## Application for a Non-Material Amendment Following a Grant of Planning Permission

DC/23/05588

Remove front door from front elevation

**Front Elevation - Proposed**  
1 : 100

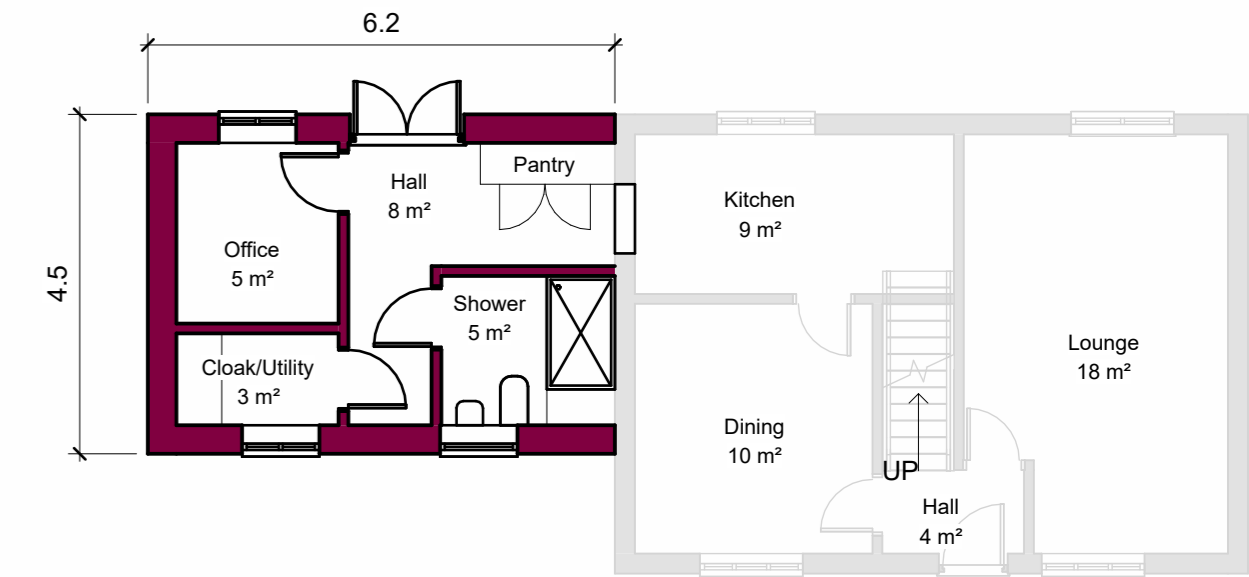
Previous house holder application DC/23/05588 was approved, my client would just like to remove the door from the front elevation
